Application Number: 2014-008 Application Date: 01/23/2014
CBL: 090 H002001 Application Type: Level II Site Plan
Applicant: REICH MARSHA A & STANLEY G REICH JTS /Stanley and Marsha Reich
Project Name: Slope Stabilization
Address: 29 OAKLAWN RD *Peaks Island*
Project Description: Stabilize the existing eroded shoreline along the waterfront property
Zoning: IR2

To: FILE
From: Phillip DiPierro
Subject: Application ID: 2014-008
Date: 2/6/2014

Project Name: **Shoreline Stabilization Project**
Project ID: 2014-008
Address: 29 Oaklawn Road, Peaks Island
CBL: 090 H 002001
Applicant: Stanley & Marsha Reich
Planner: Philip DiPierro

SITE LAYOUT PLAN

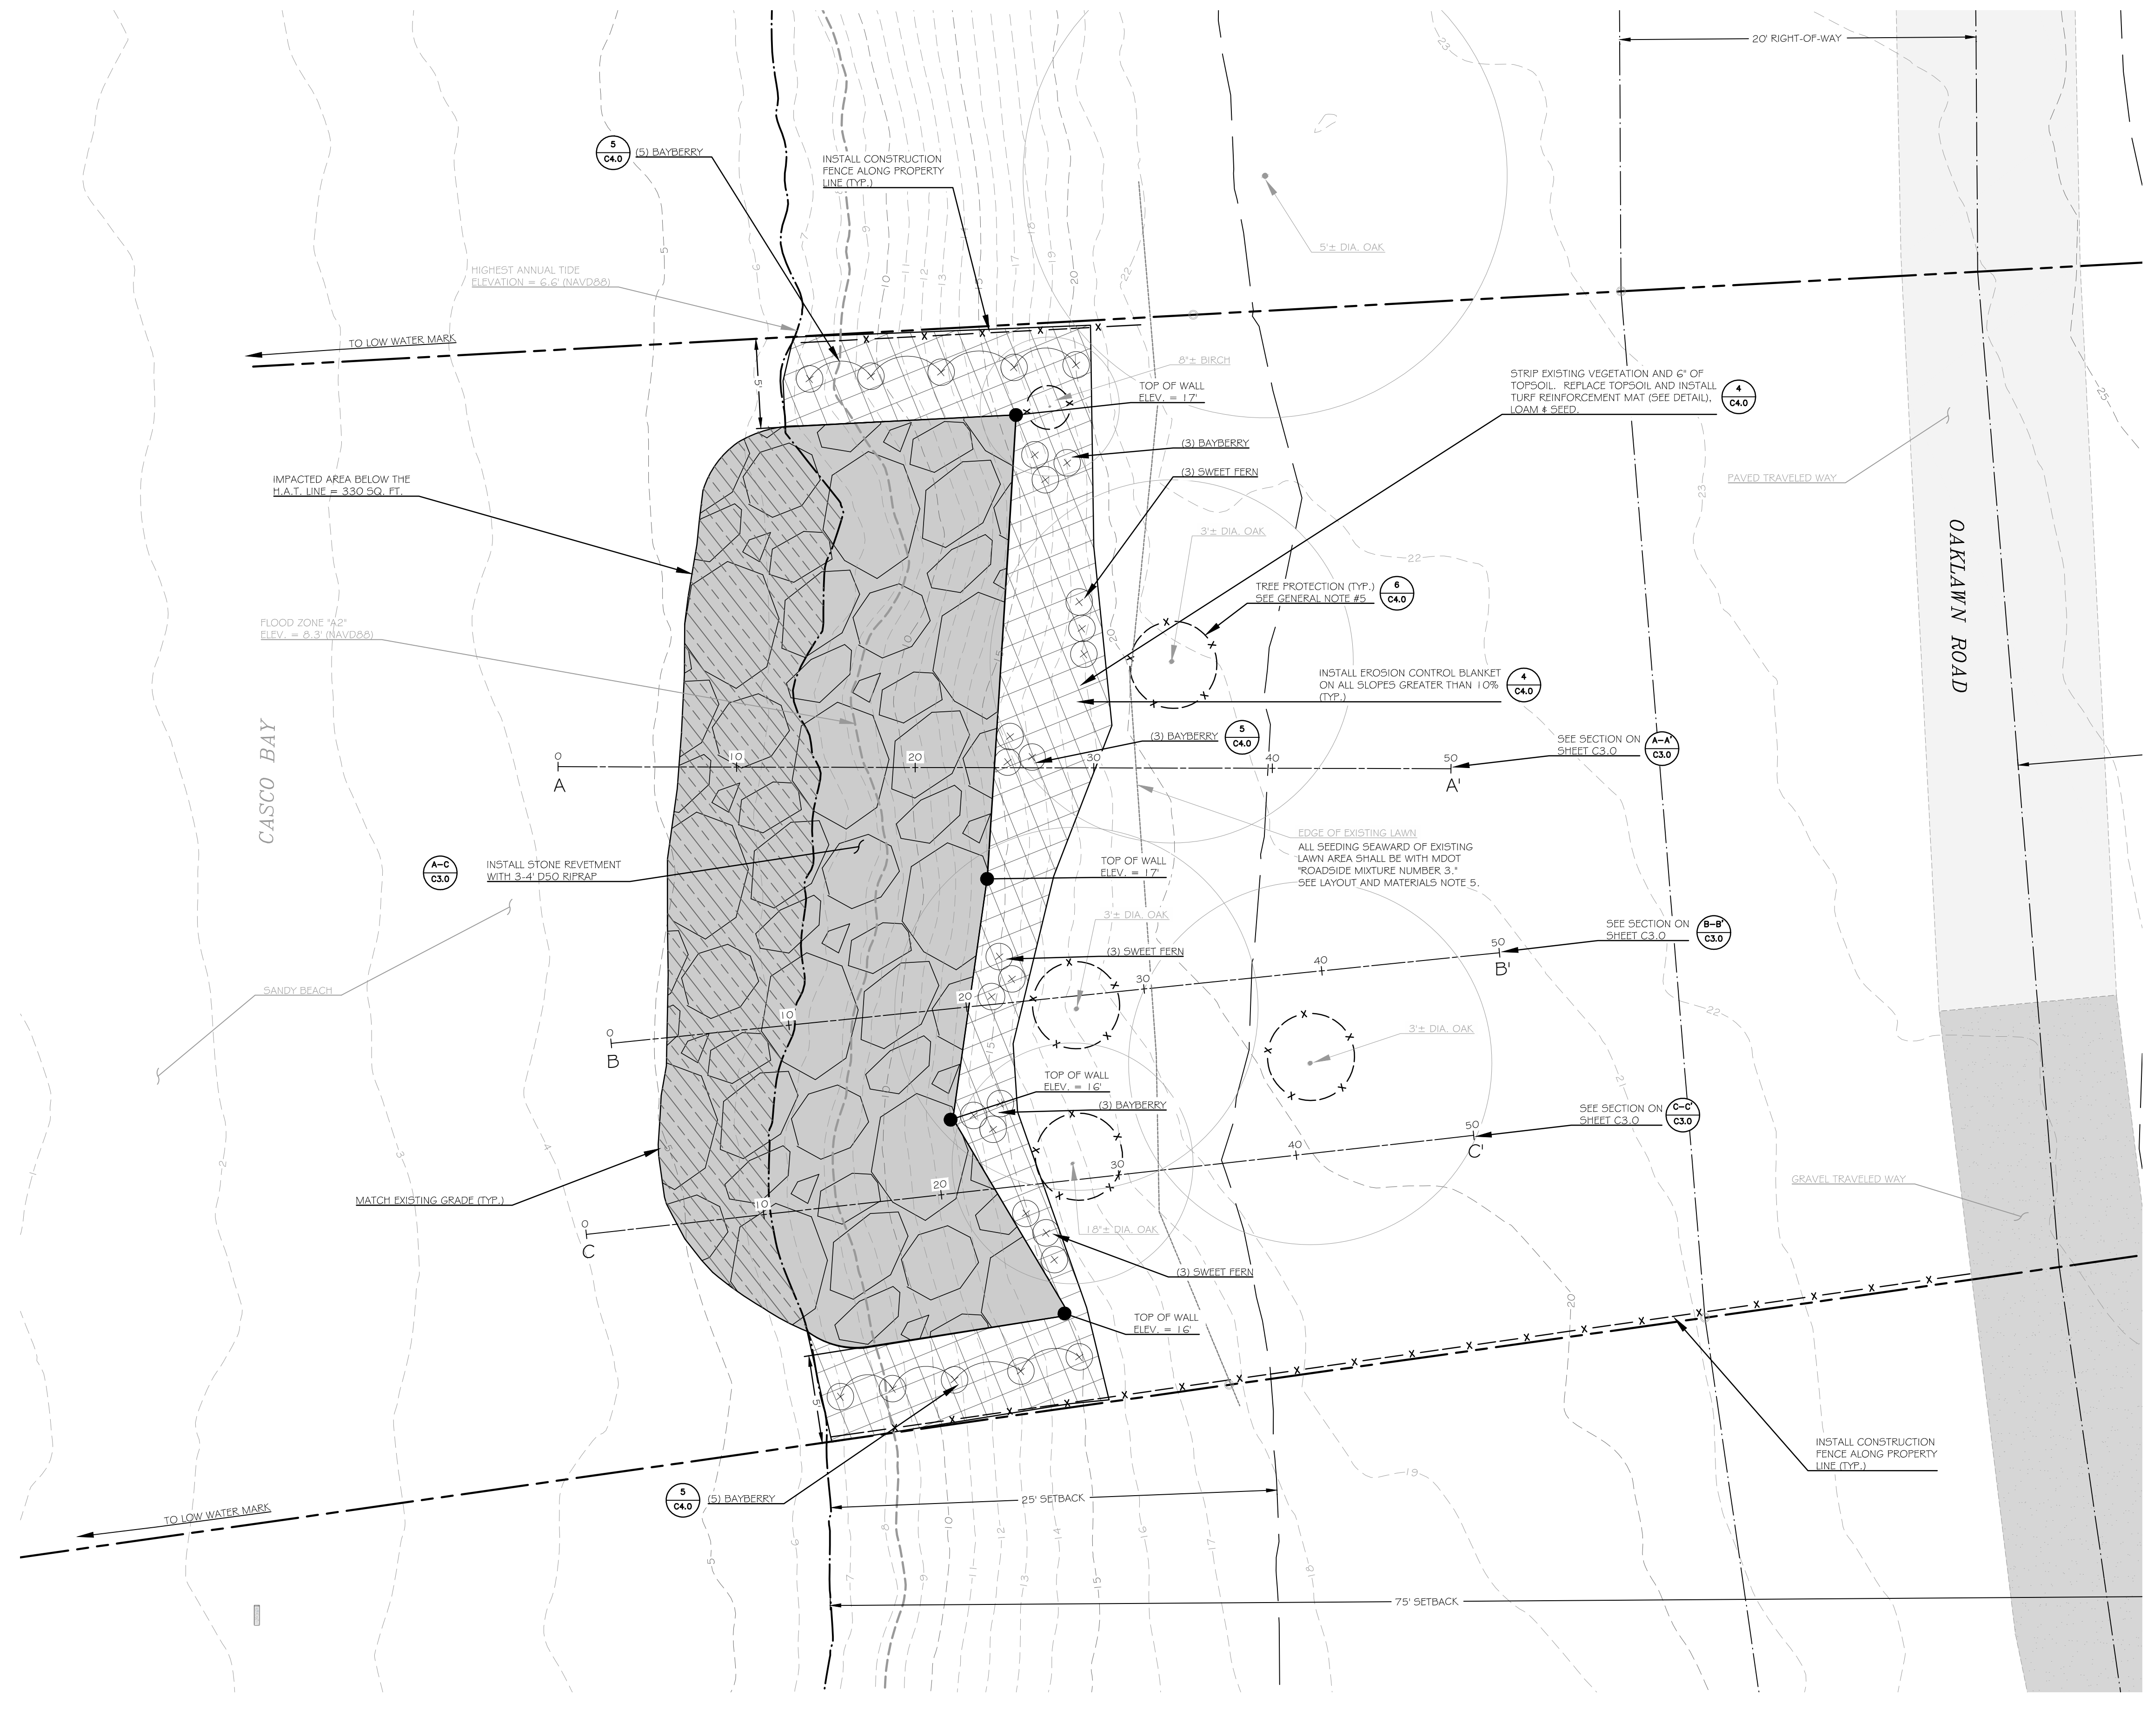
They could use additional Bayberry plants... five per side minimum. Perhaps a couple of groups of three up top. The plant cost is pretty minimum and would be good to establish greenery along the bank edge.

3. A revised landscape plan shall be submitted, for review and approval, to address the review comments of the City Arborist, Jeff Tarling.
